**Consultation Response from KC,
Lead Local Flood Authority**

2024/90792 Former Whiteley Engineering Works Site, St. Peg Lane, Cleckheaton, BD19 3SH

Use of land for storage and fit-out of acoustic containers with generator units and associated electrical equipment, with reinstatement of former access to St. Peg Lane, erection of security fence and siting of security and welfare cabins

Date Responded: 9th September 2024

Proposed Site Plan

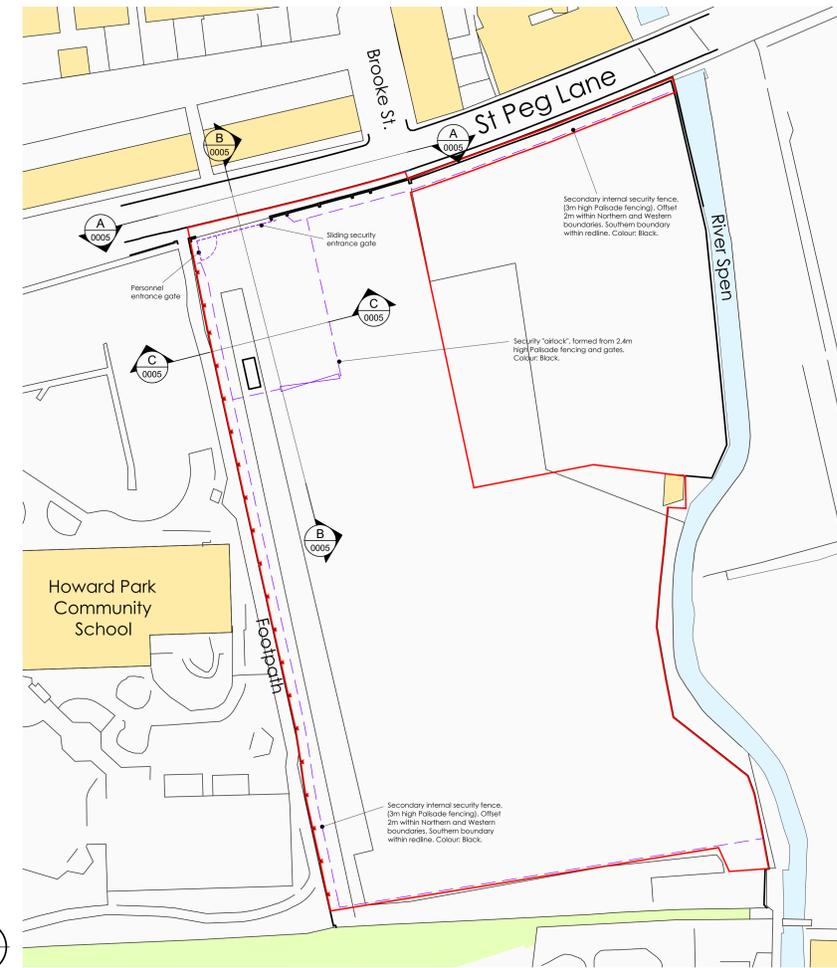
- As there is no 'built' development proposed at the site or any changes to ground surfacing, I am satisfied that there is no increase in flooding, and that no changes are required regarding drainage/attenuation/discharge rates.
- The Genset Enclosures (containers) will discharge water onto the ground, which will be managed by the existing drainage at the site.
- Implementing a Flood Warning and Evacuation Plan would help address the EA's concerns regarding any residual scenario of flood water emerging from the river walls on site and outline what to do on site based on different severity flood alert/warning codes.
